From: planning
Subject: FW: FAO Victoria Walmsley: Consultation on planning application 3/2016/0957 23 Pendleton Road, Wiswell BB7 9DD

Planning application 3/2016/0957 at 23 Pendleton Road, Wiswell, BB7 9DD

The application is for a two storey extension to the side, relocation of driveway and detached double garage and workshop to rear.

PROPOSED SITE PLAN

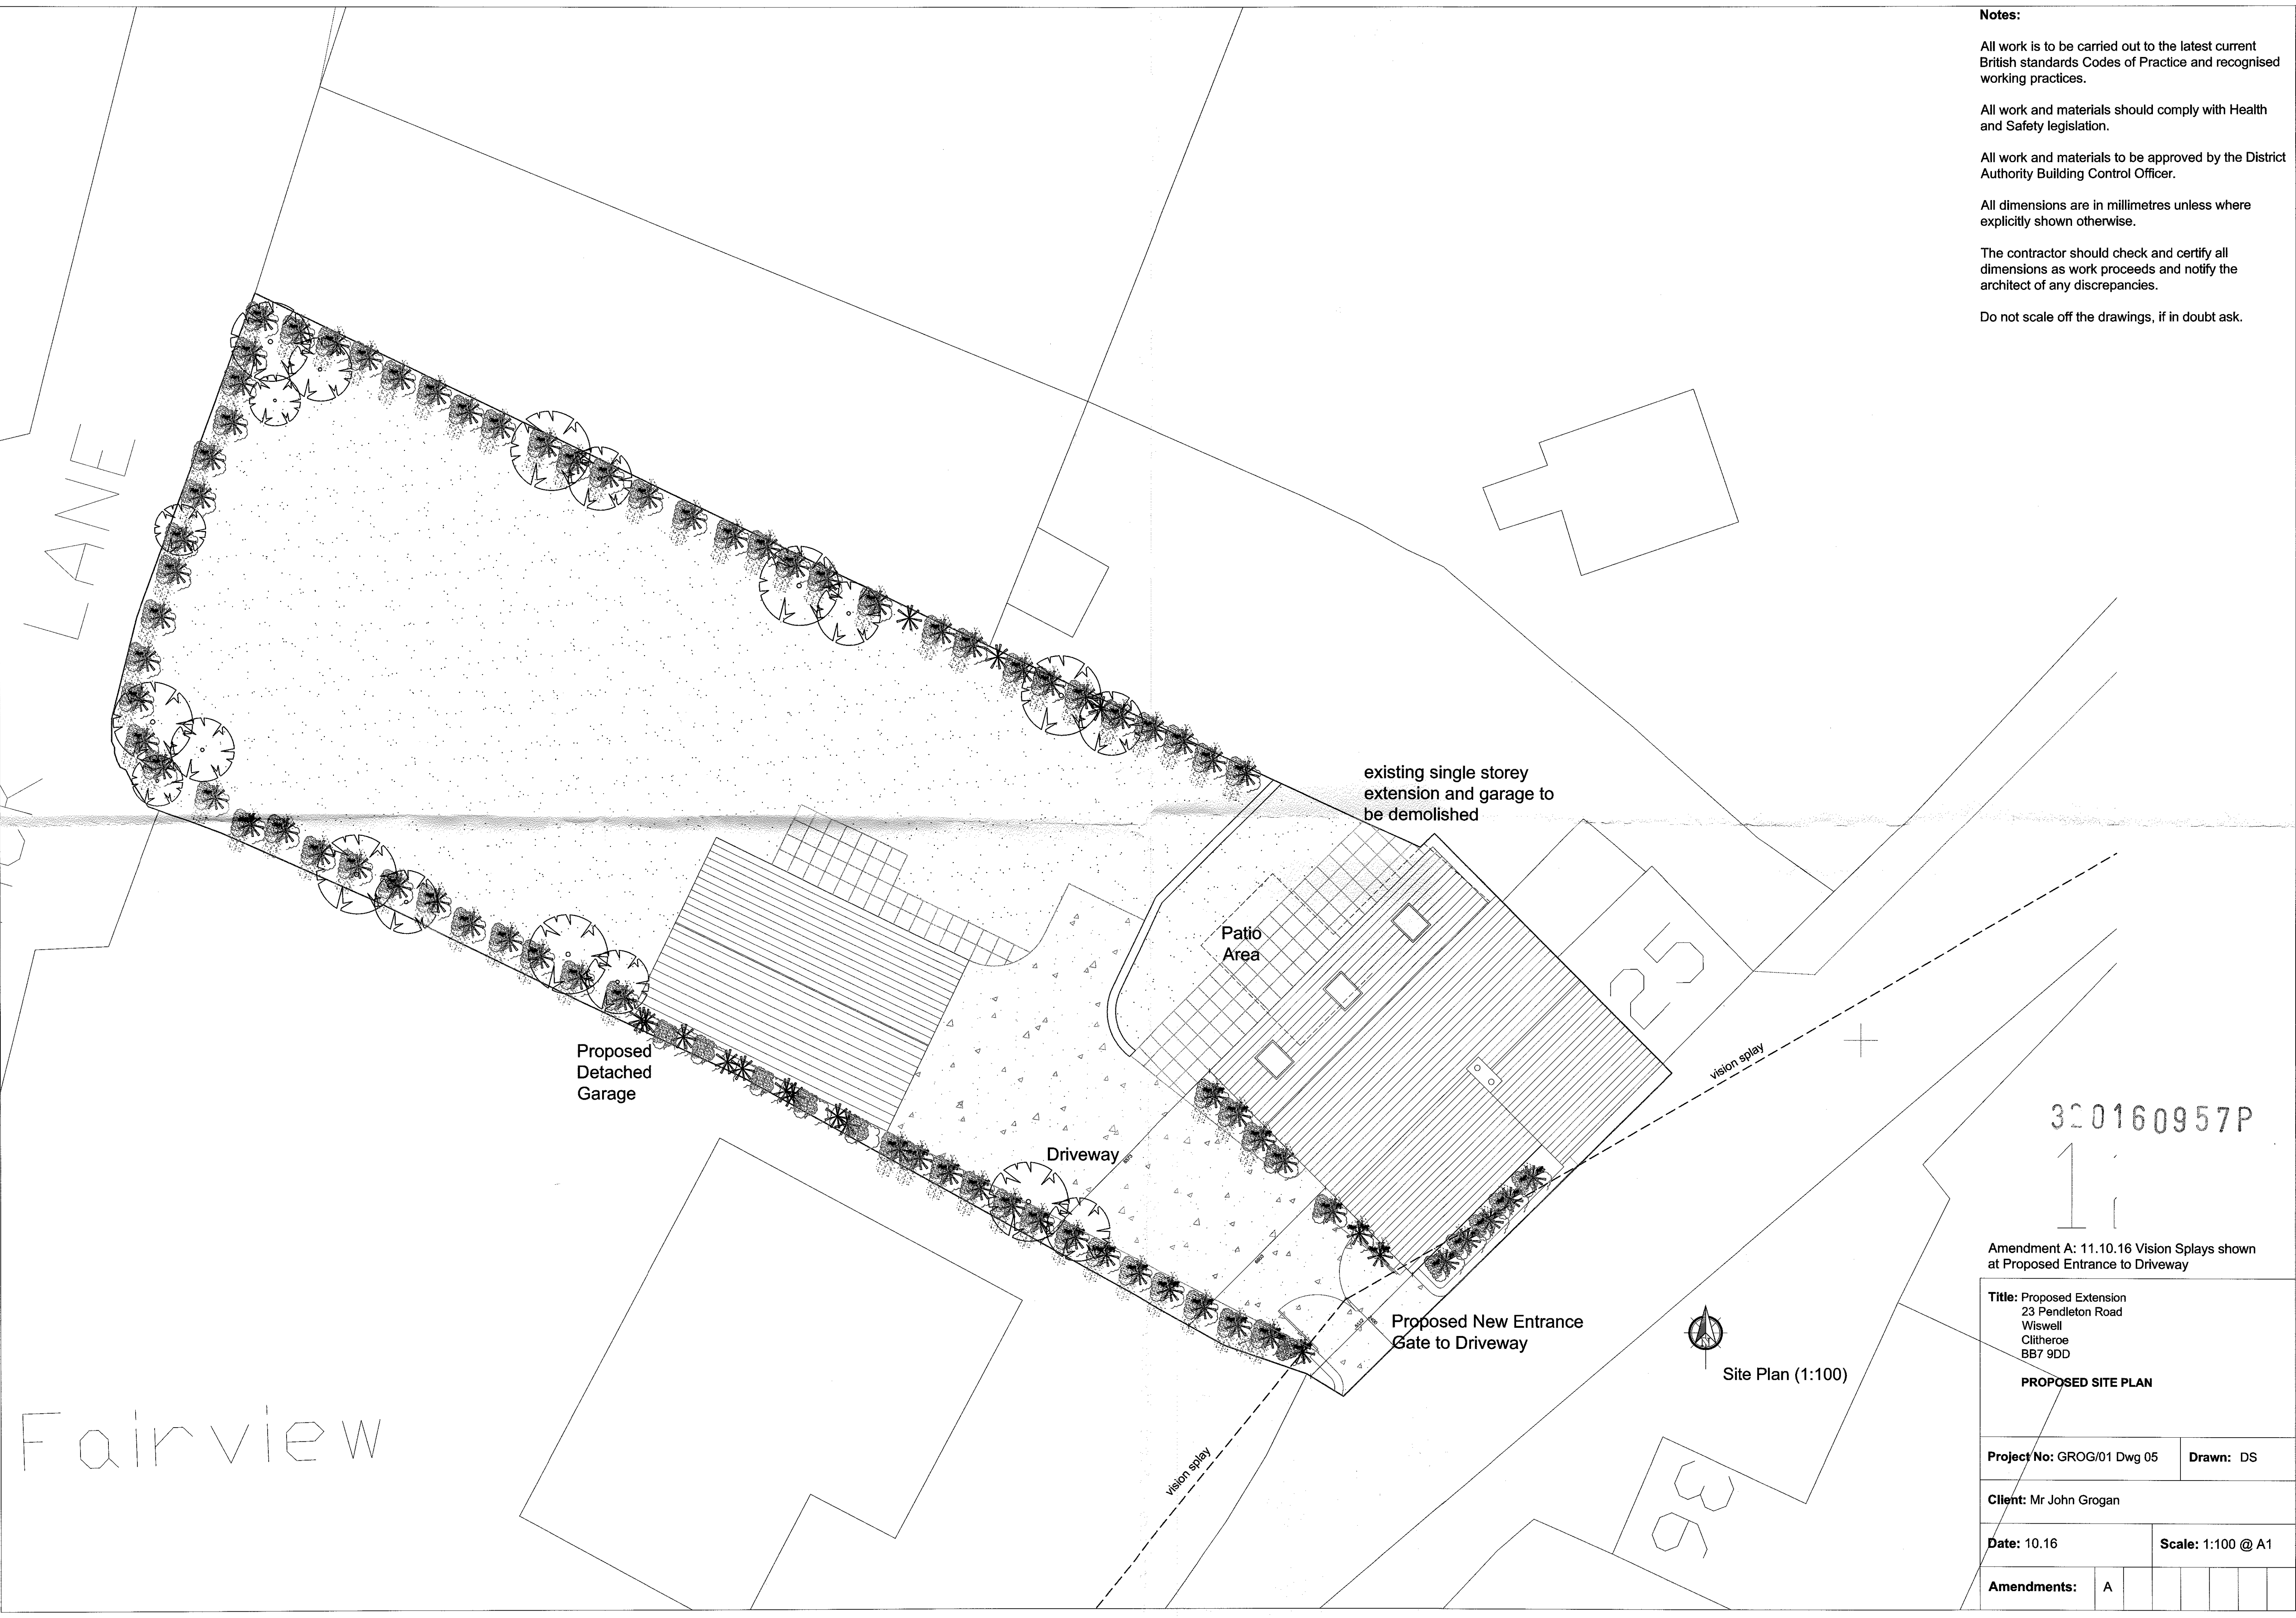
The proposed extension and increased frontage would be detrimental to the street scene in a conservation area. The existing cottages are well spaced with open spaces between them and other properties on Pendleton Road. Increasing the frontage of 23 Pendleton Road would make the cottage look out of place with its neighbour and create a terraced row effect which is not the street scene on this part of Pendleton Road. The increase in volume is far too great and not in keeping with 25 Pendleton Road; the two properties would look out of proportion next to each other.
